# BCA ASSESSMENT REPORT

BCA Report for proposed industrial buildings  
Kemps Creek, Kemps Creek

Prepared for: Frasers Property Issue date: 15 Nov 2021

DRAWING TITLE: Warehouse 1 & Office 1 Floor Plan  
DRAWING NUMBER: SP-KC1-DA - 101 - P

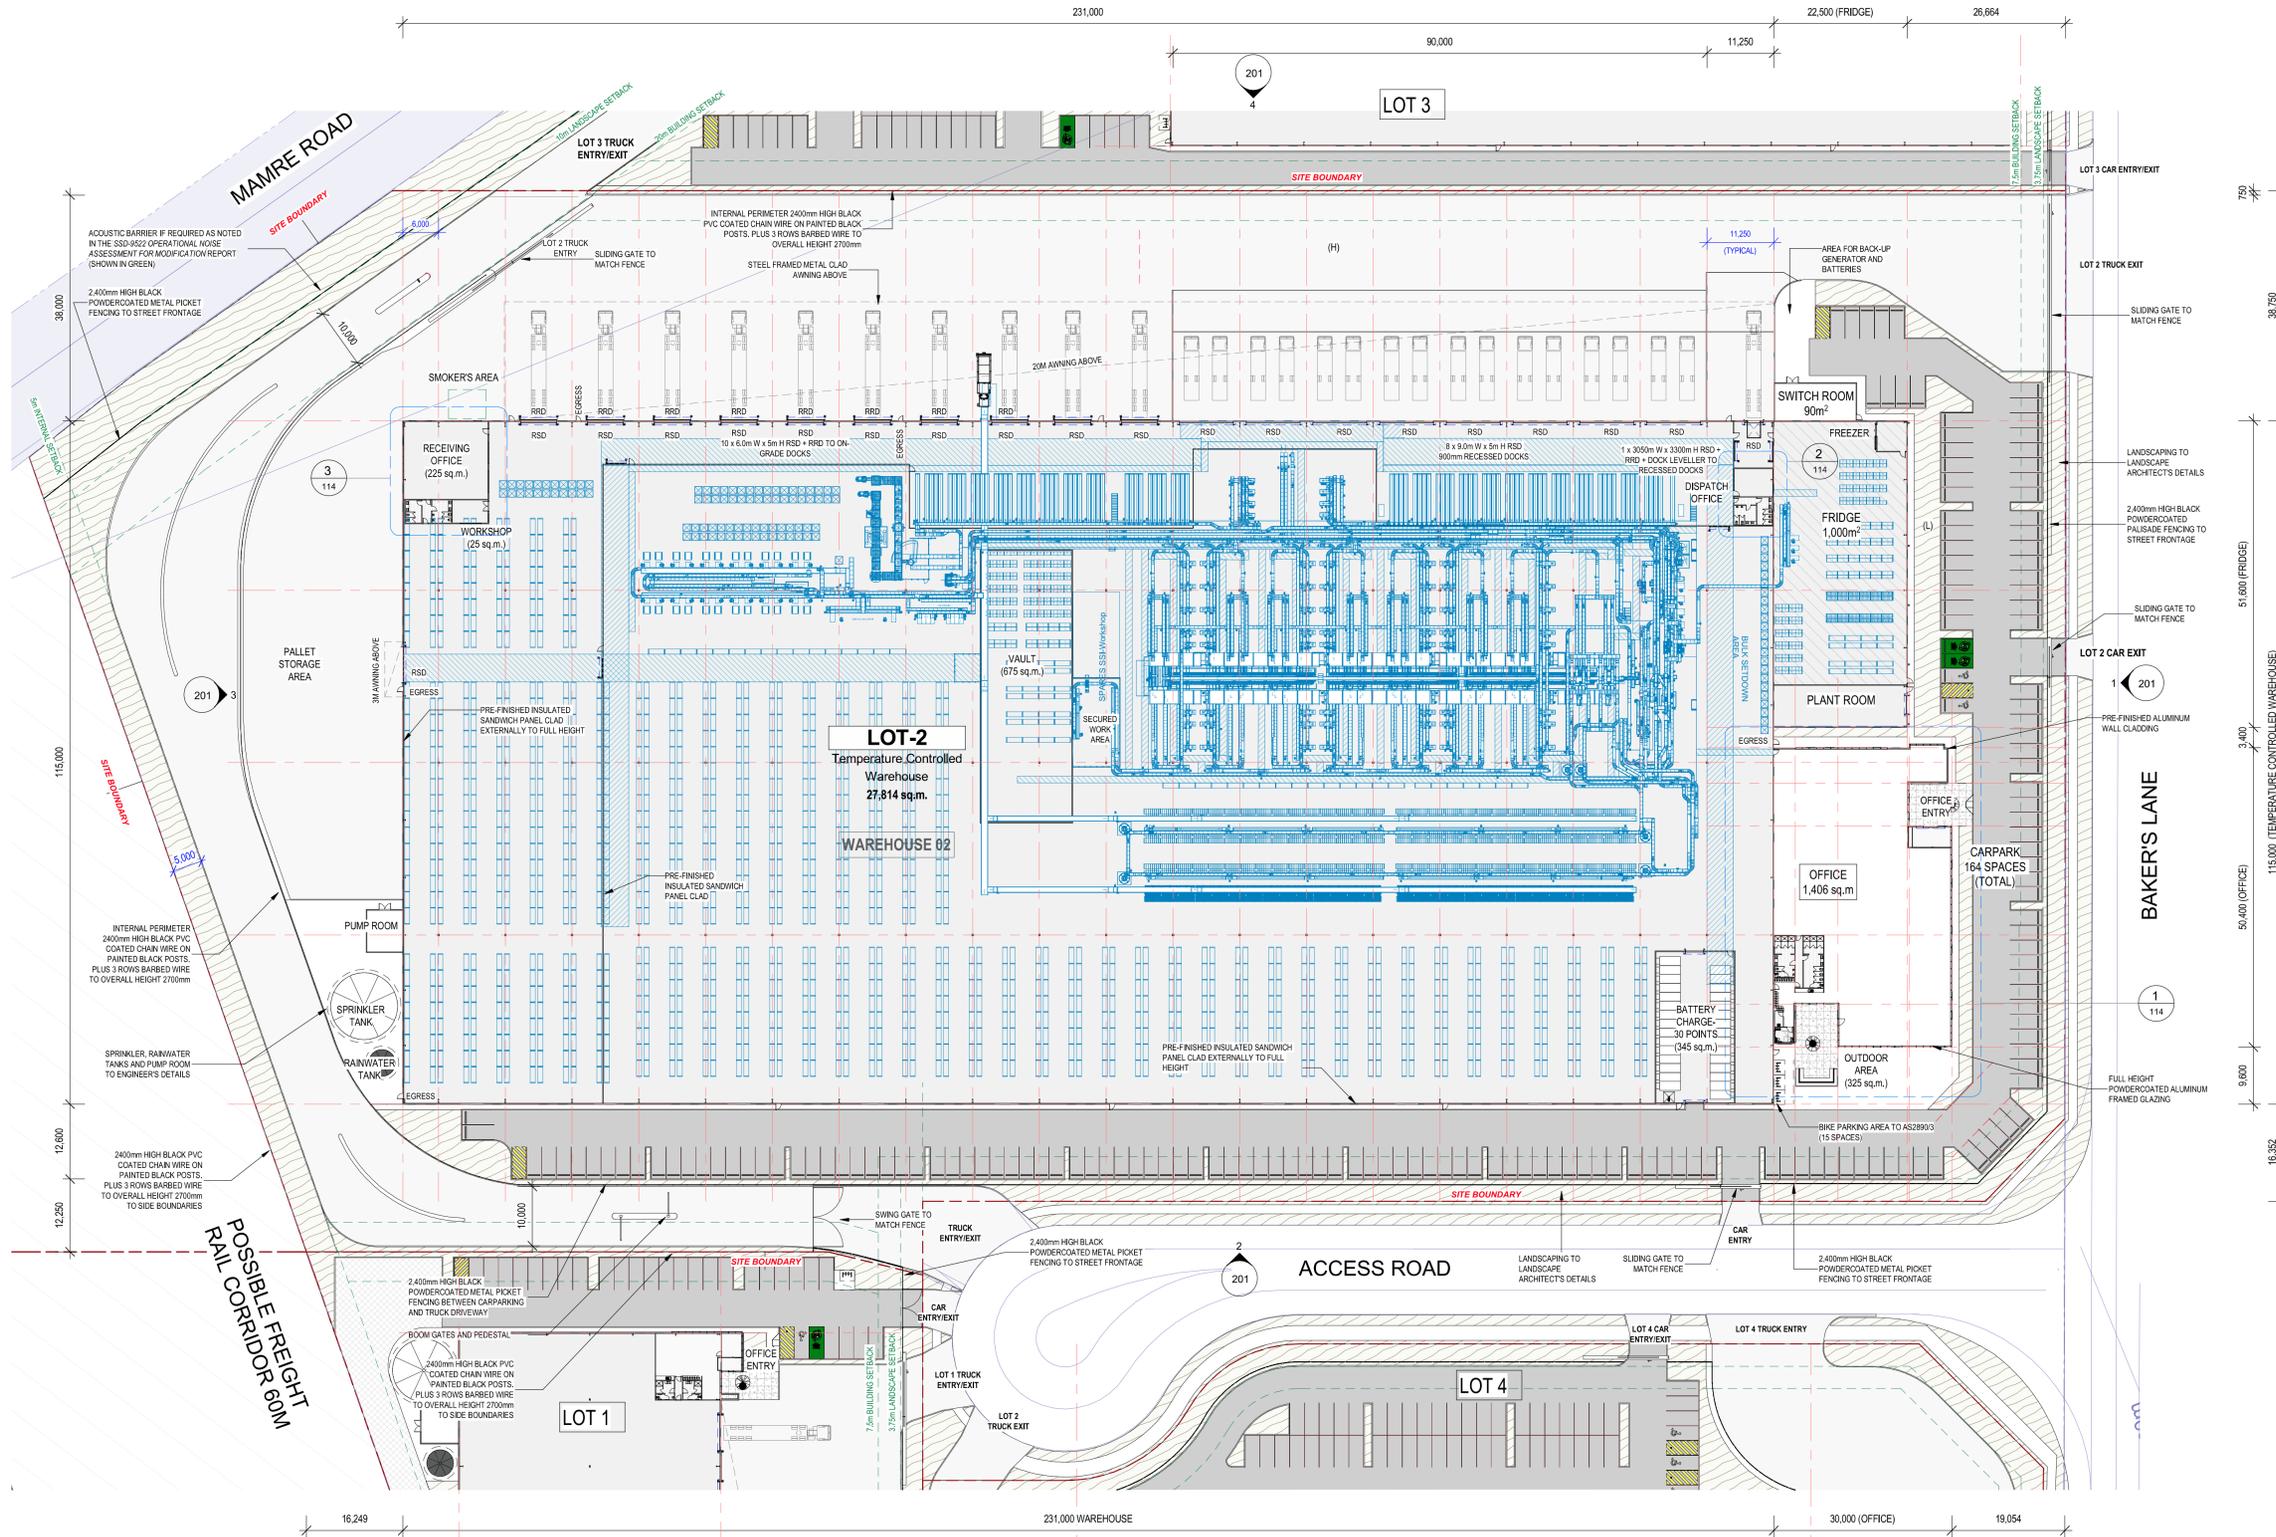
DTS Clause	Description of Non-Compliance	Performance Requirement
C2.4	<p><u>Requirements for open spaces and vehicular access</u></p> <p>Access for emergency vehicles is not provided to the following areas:</p> <p>Lot 1</p> <ul style="list-style-type: none"> <li>▪ Greater than 18m to South elevation</li> </ul> <p>Lot 2</p> <ul style="list-style-type: none"> <li>▪ Greater than 18m to all elevations</li> </ul> <p>Lot 3</p> <ul style="list-style-type: none"> <li>▪ Greater than 18m to the East &amp; South elevations</li> <li>▪ Not provided to the North &amp; West elevation</li> </ul> <p>Lot 4</p> <ul style="list-style-type: none"> <li>▪ Greater than 18m to the North, East &amp; South elevations</li> </ul> <p>Boom gates are located within the perimeter vehicle access.</p> <p>Should vehicular access not be provided in accordance with the deemed-to-satisfy provisions of the BCA, the vehicular access will be required to be addressed against the Performance Requirements of the BCA and in consultation with Fire and Rescue NSW.</p>	CP9
